Response to Submissions

Traffic and Parking

Hurlstone Agricultural High School (Hawkesbury)

20 August 2018

BUILDING 4 - GROUND FLOOR

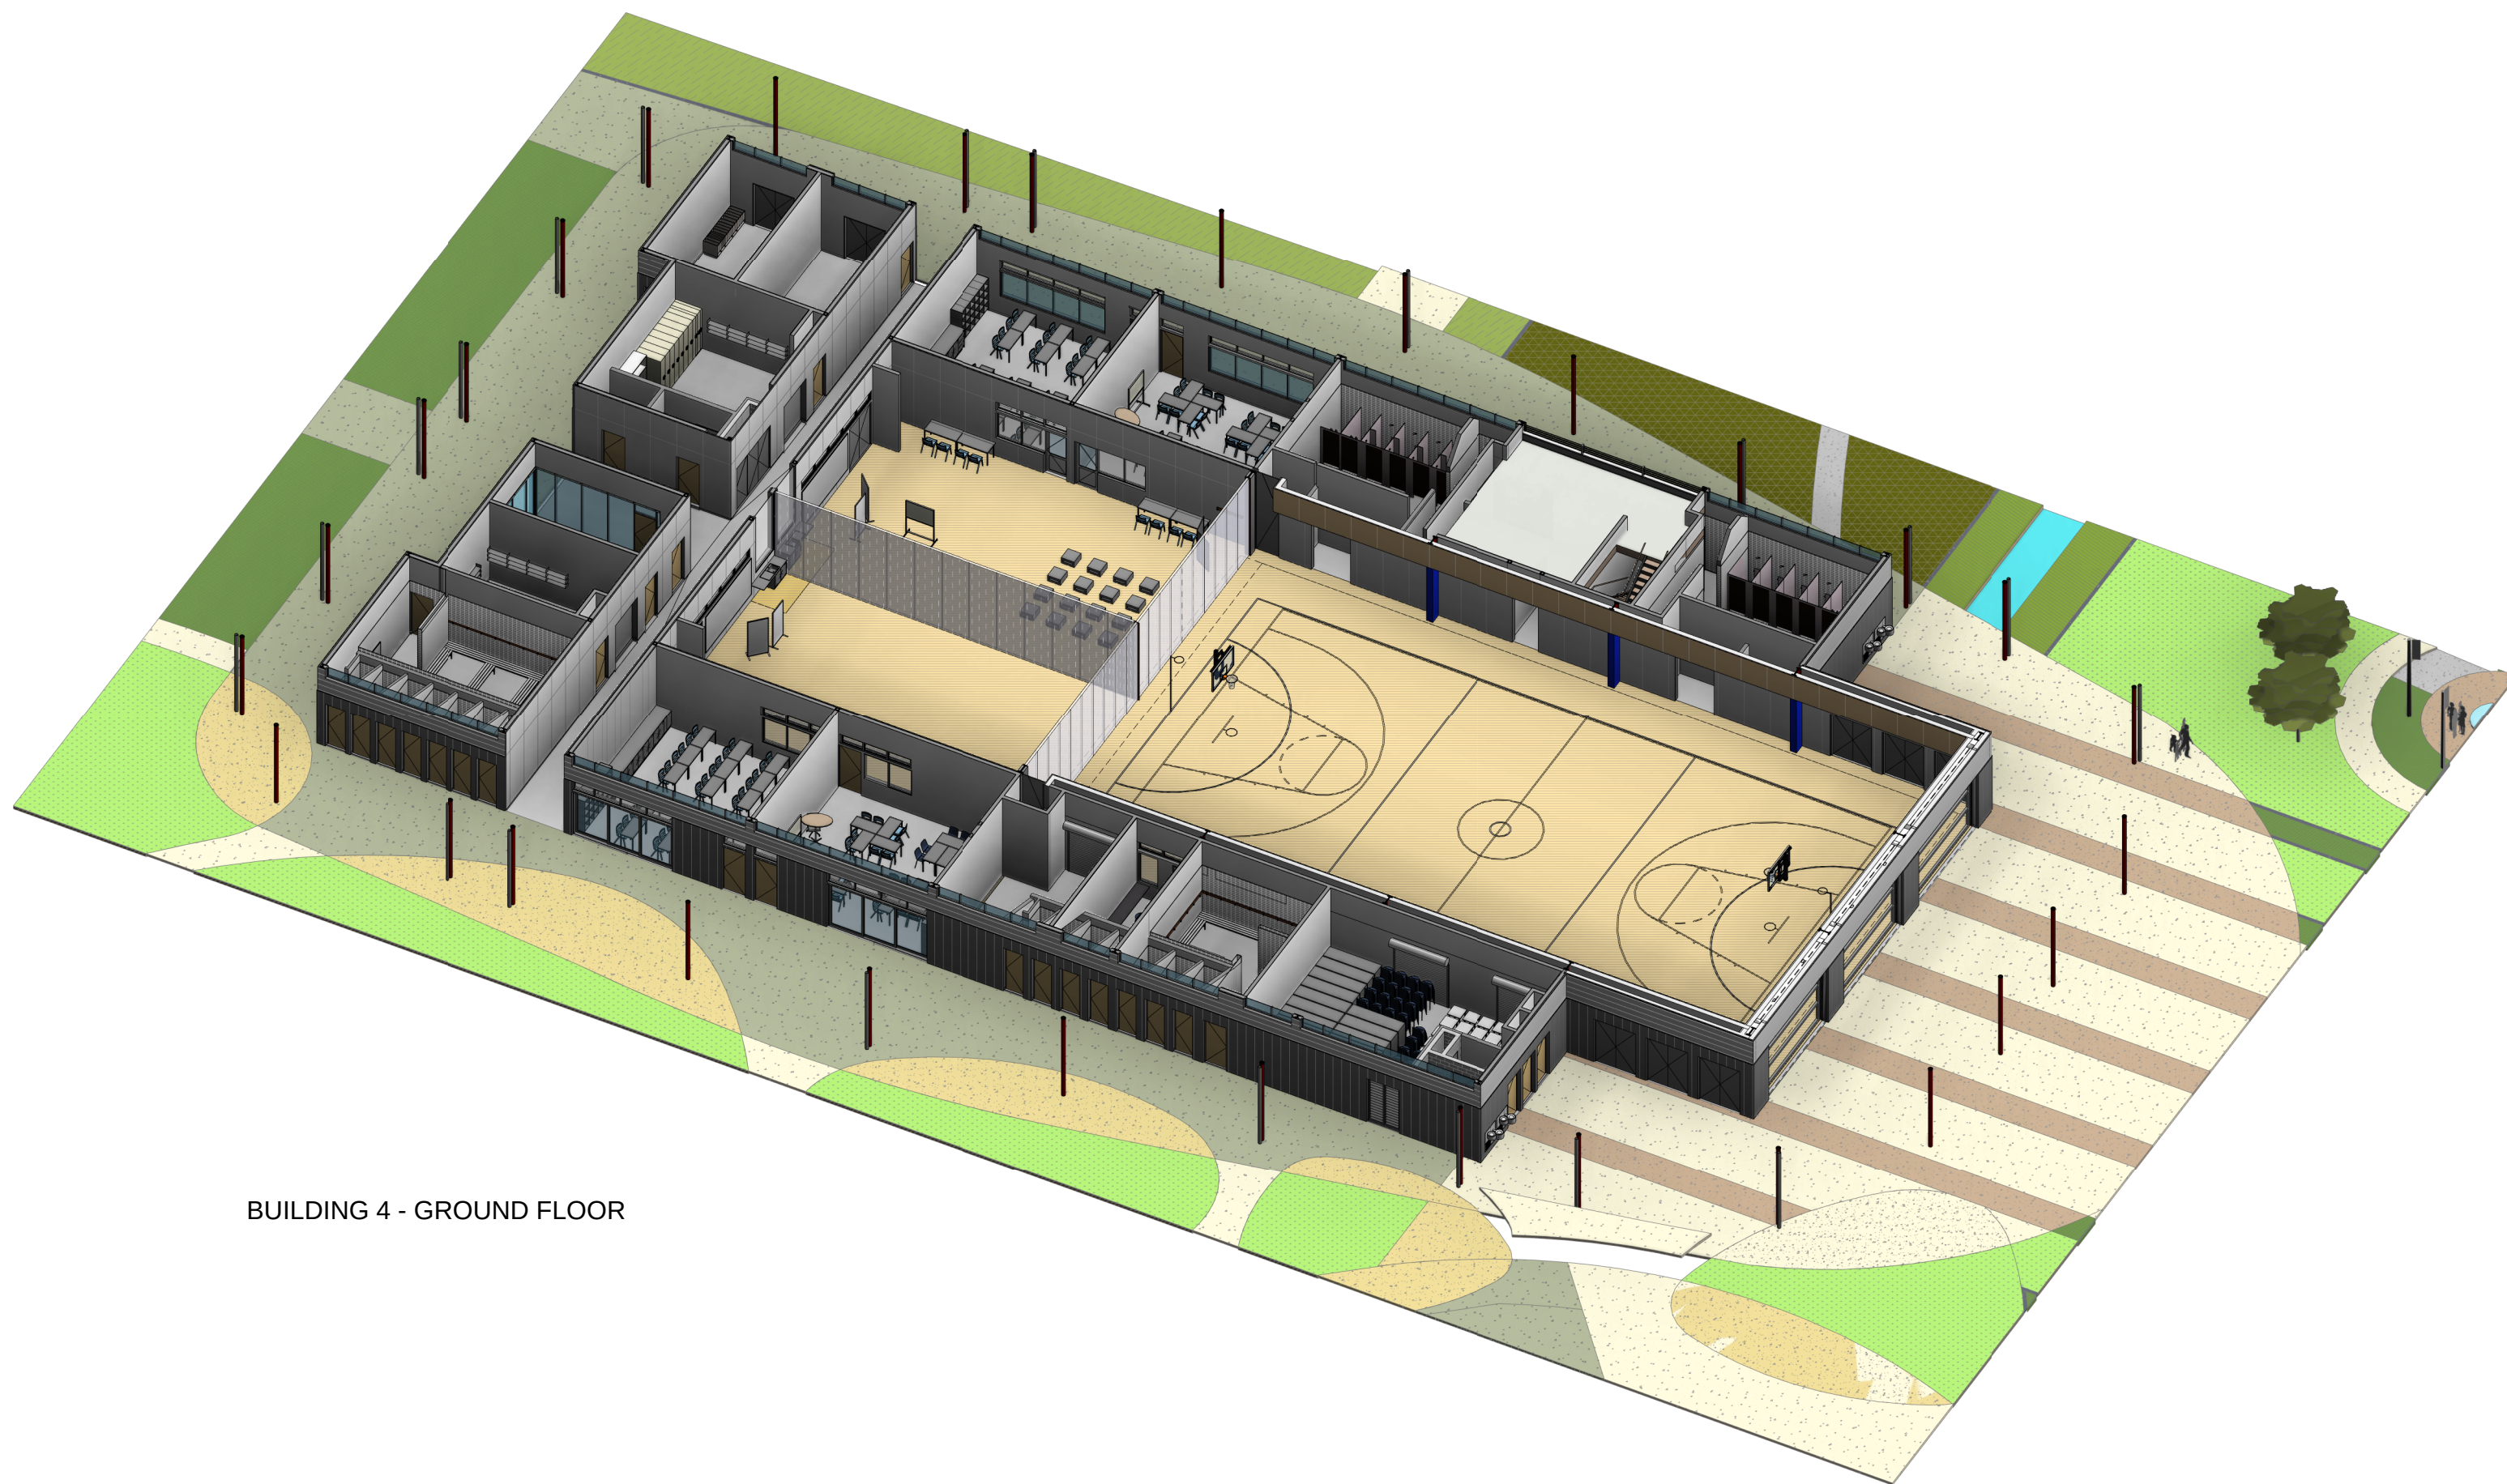
TfNSW has noted that bicycle parking should be included on architectural drawings. The revised architectural set demonstrates a proposed bicycle storage shelter beside Building 4 (Hall), with capacity for 60 bicycles. End of trip facilities will be provided in the Hall.
